SUBJECT: Engineering Review Comment
Mountain View Electric Association Inc. (MVEA)

Project Name: Northcrest Personal Storage Condo Plat

Project Number: SF267

Description: Proposed development of 1 commercial lot located at Canada Dr. and Bismark Rd. in Township 13S, Range 65W, Section 32.

CONDOMINIUM MAP
MY GARAGE AT NORTHCREST

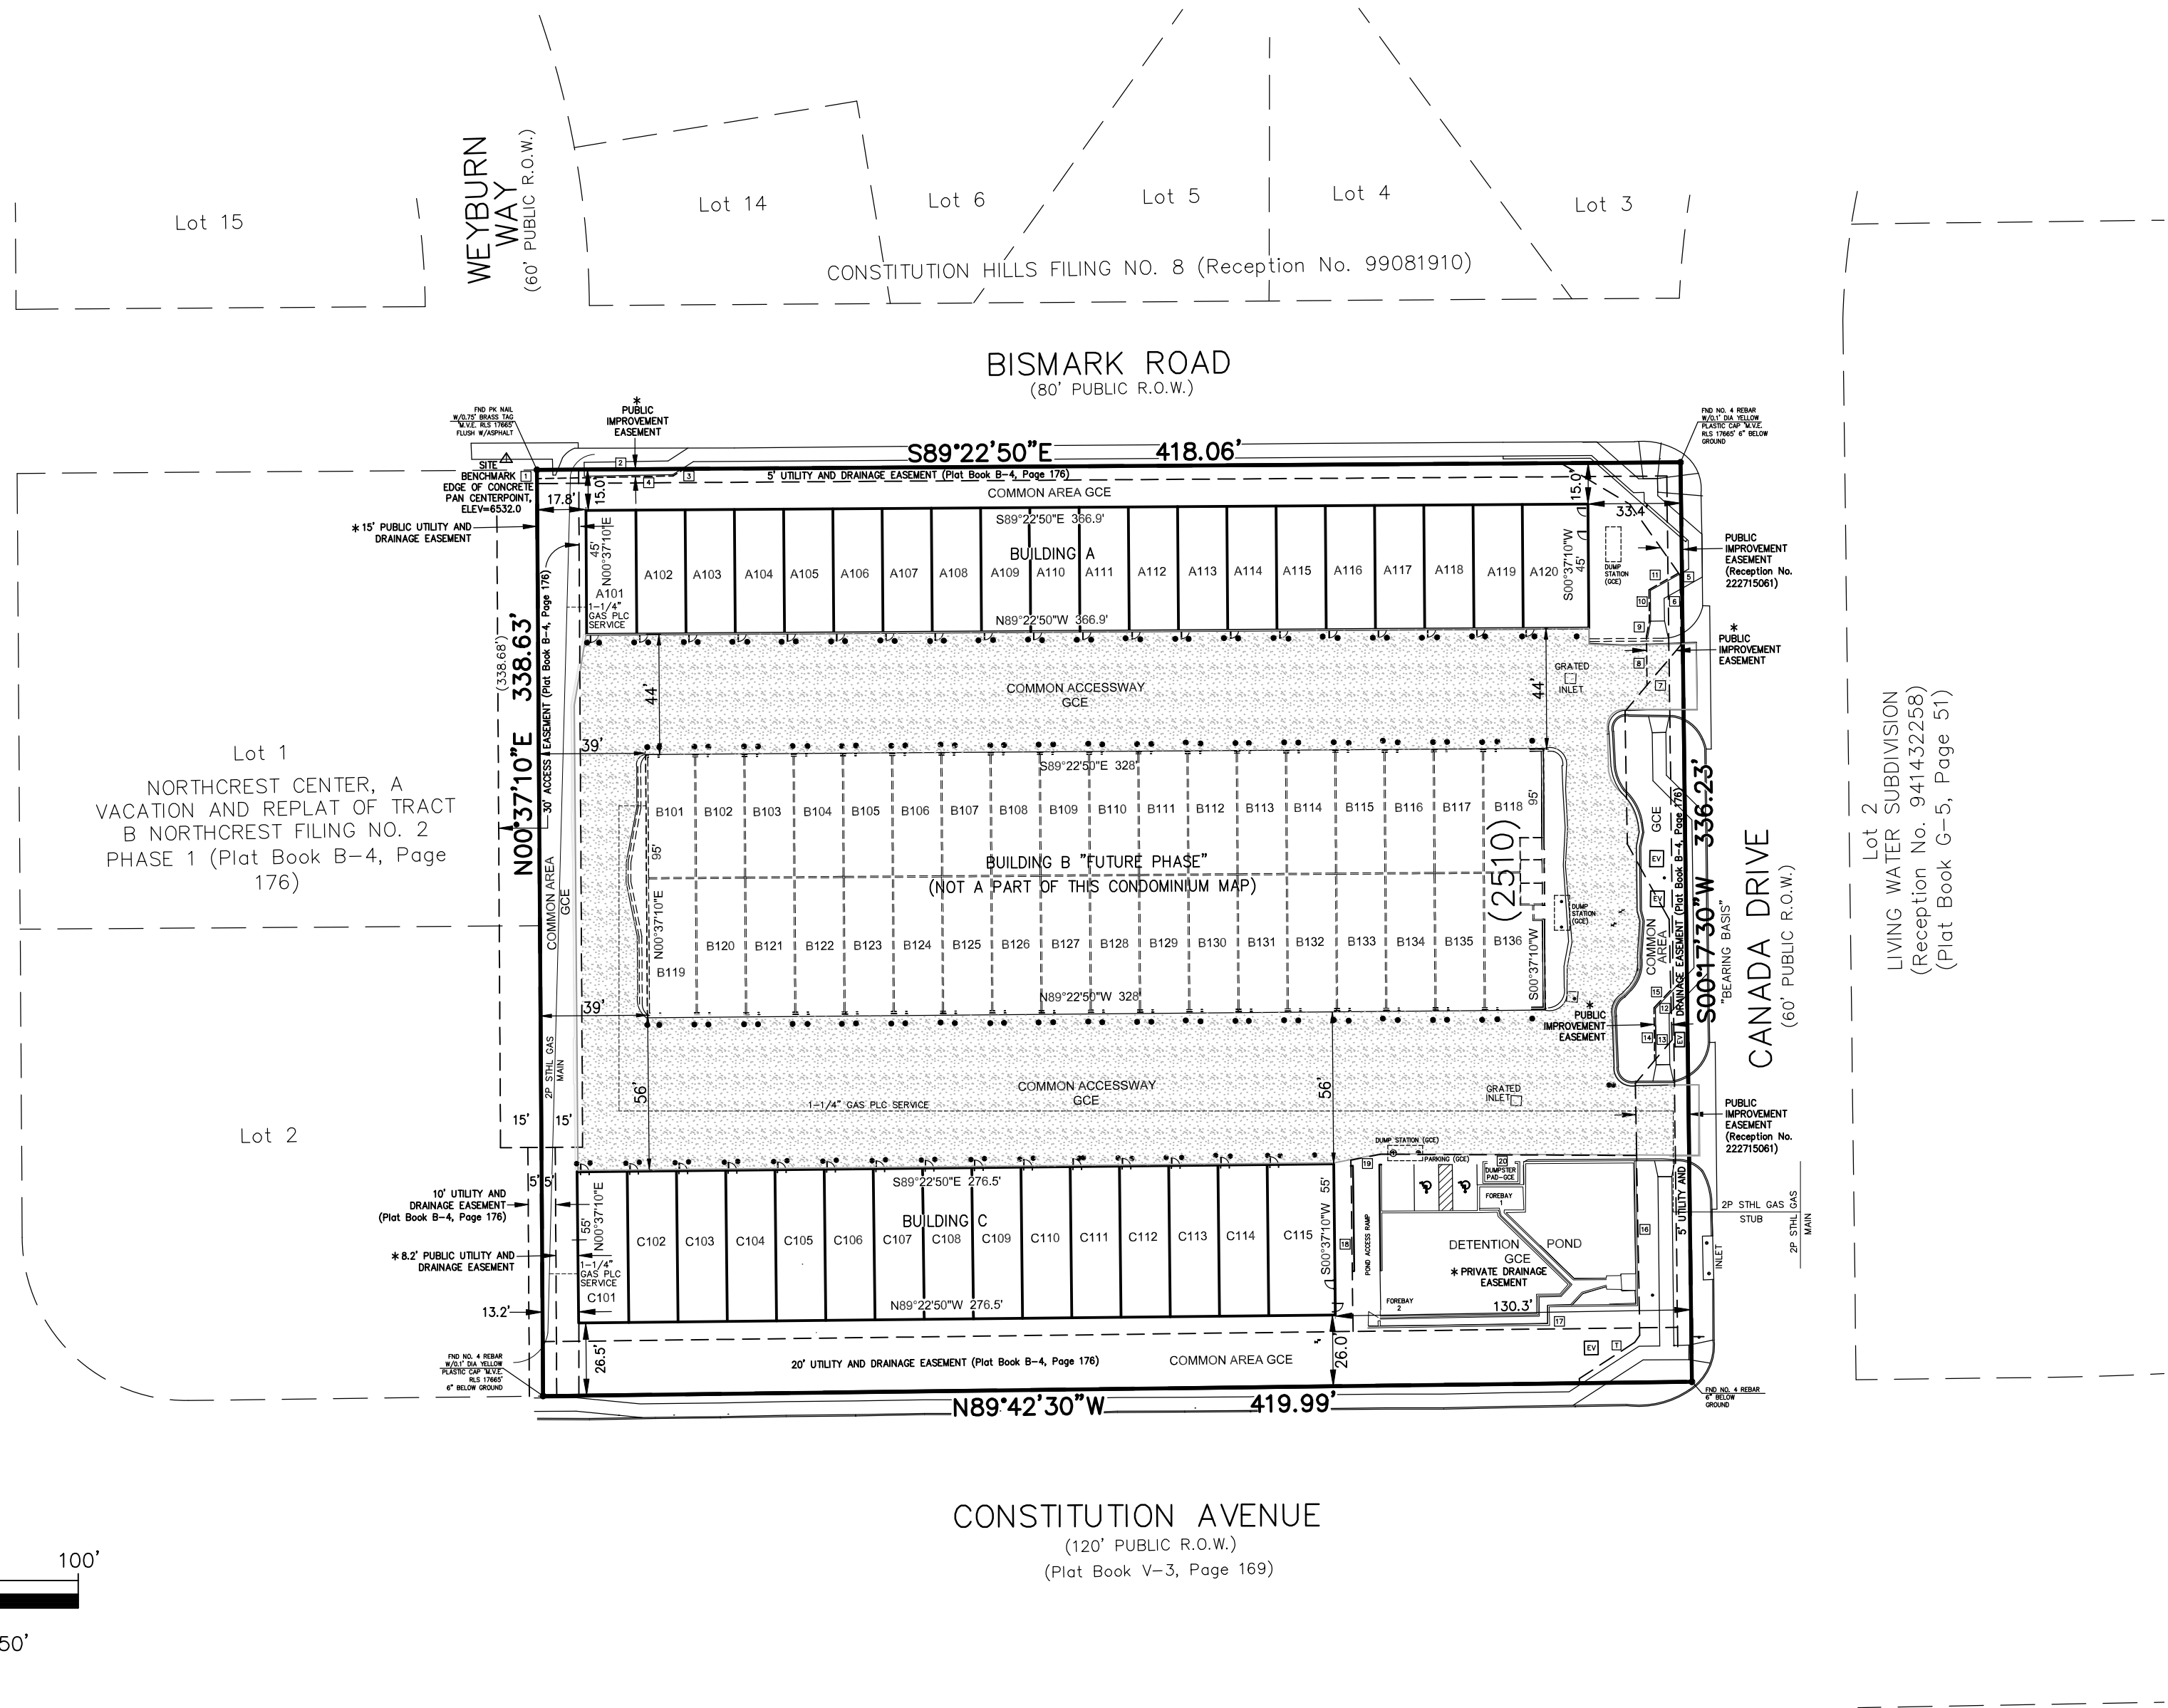
MVEA requests a ten (10) foot front, side, and rear lot utility easement and all tracts, along with a twenty (20) foot exterior utility easement on the plat. MVEA also requests the platting of MVEA's existing facilities with easements on the plat. Additional easements may be required.

MVEA has existing electric and/or broadband facilities near and within this parcel of land. If there is any damage, removal or relocation of facilities it will be at the expense of the applicant.
